Application for a Non-Material Amendment Following a Grant of Planning Permission

Roof extension involving side dormer window and 2no conservation rooflights.
Single storey rear bay extension of 3500mm x 2000mm x 3200mm.

21/4021/HSE

**EXISTING & PROPOSED**  
 Ground Floor Plan

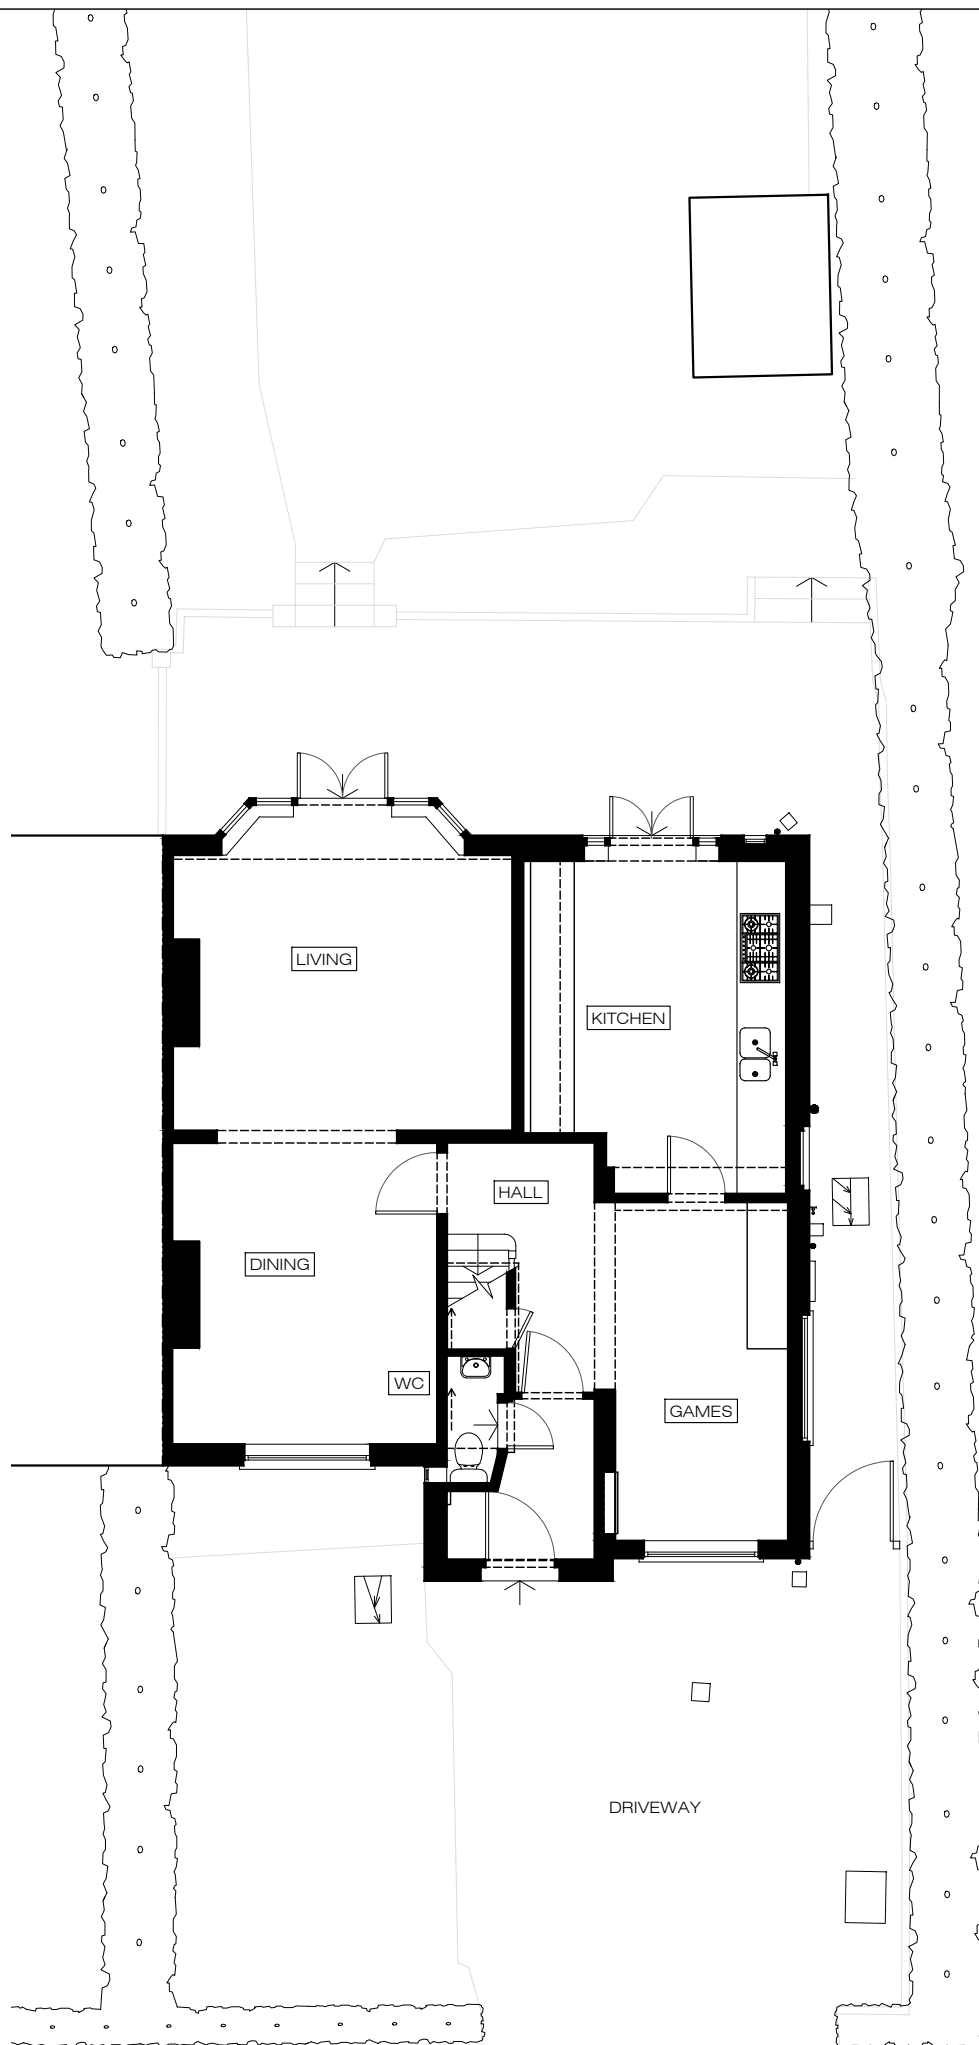
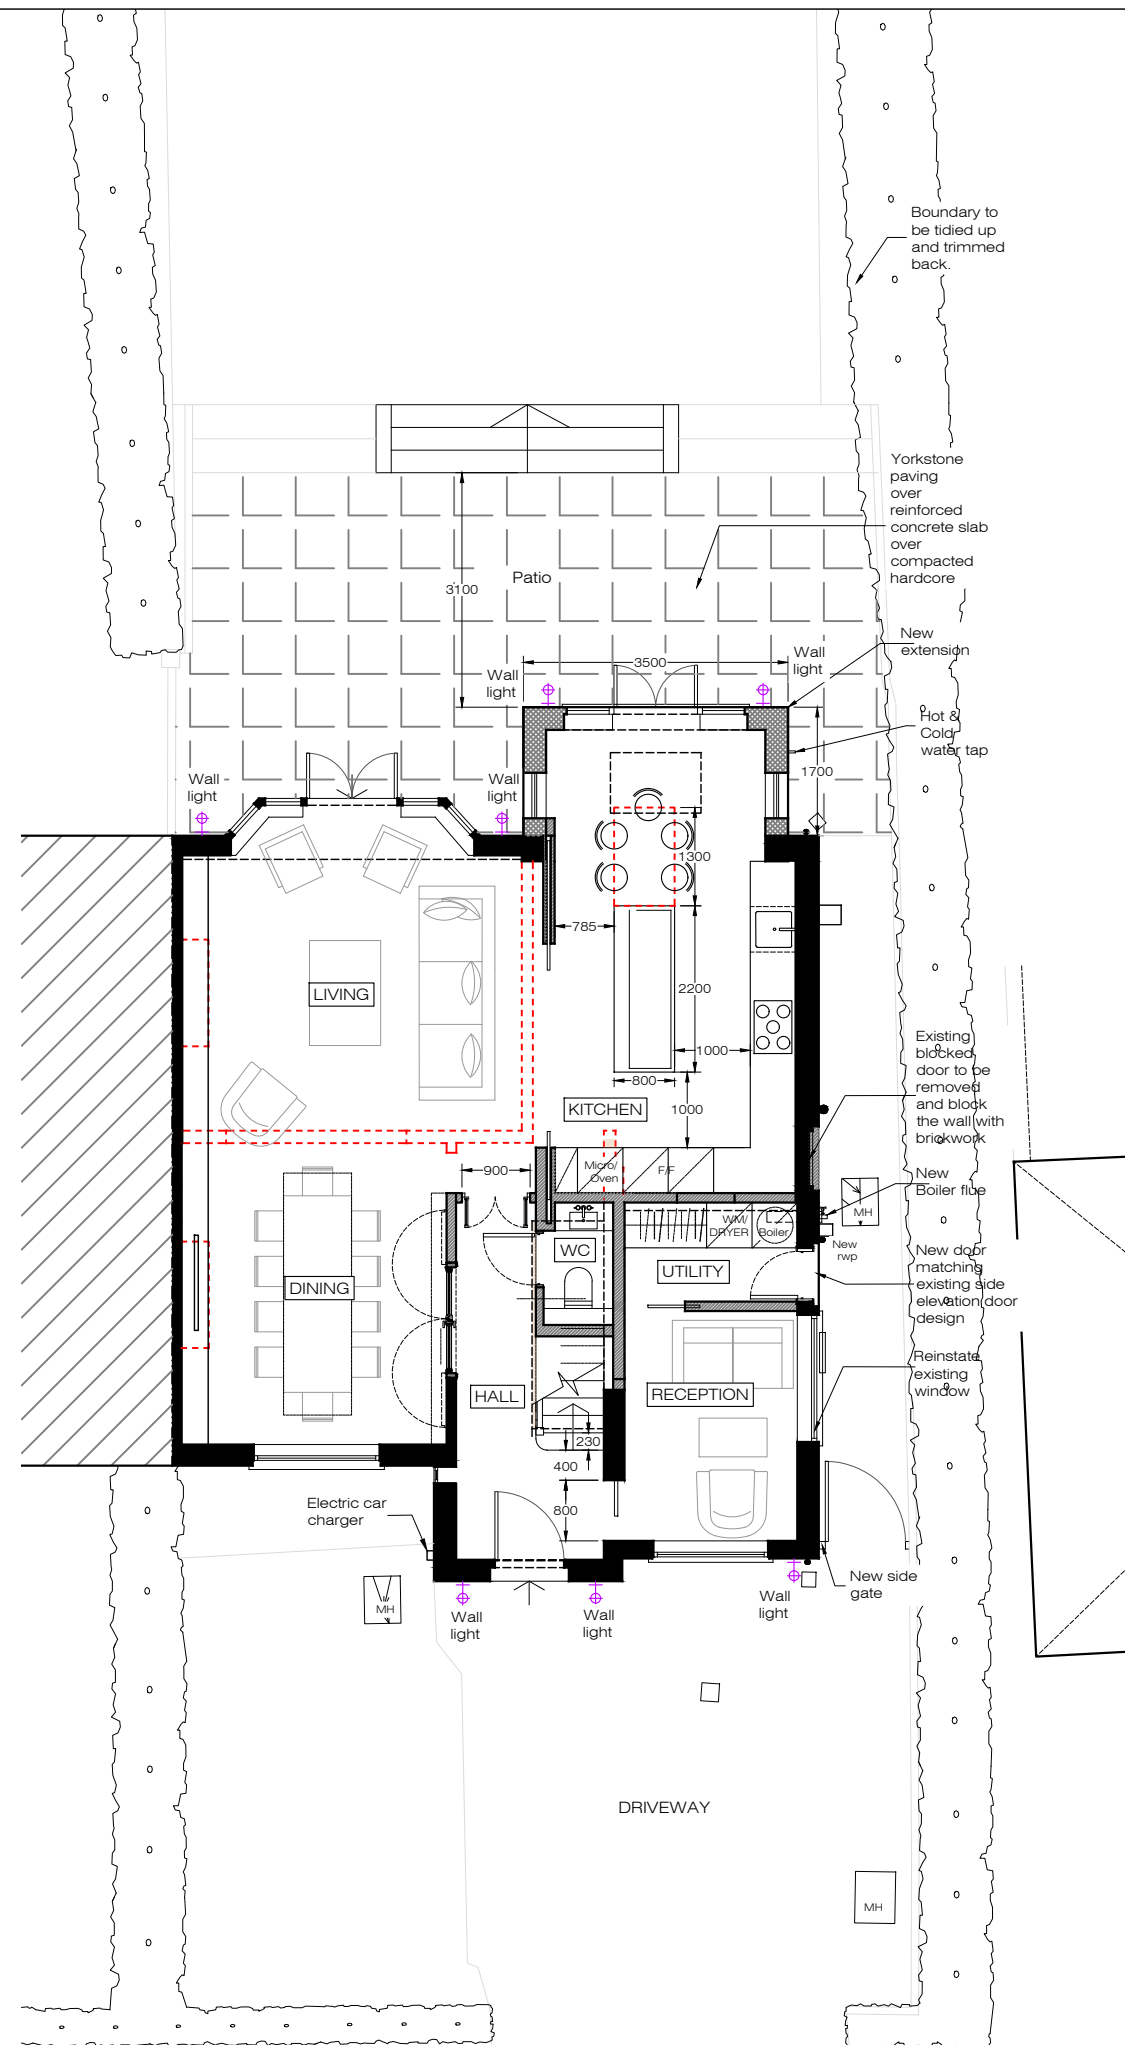
- The proposed extension size is reduced to 1700 x 3500.
- Window Replacement: the side elevation first-floor bathroom window will be replaced to match the other existing windows.
- Rear elevation French doors to match existing rear bay window door design style.

The proposed rear extension now falls within the roofline of the main roof rear pitch as per Hamstead Garden Suburb Trust's comment. Also as per Trust's request we are reinstating windows and windows/doors are proposed to match existing design style.
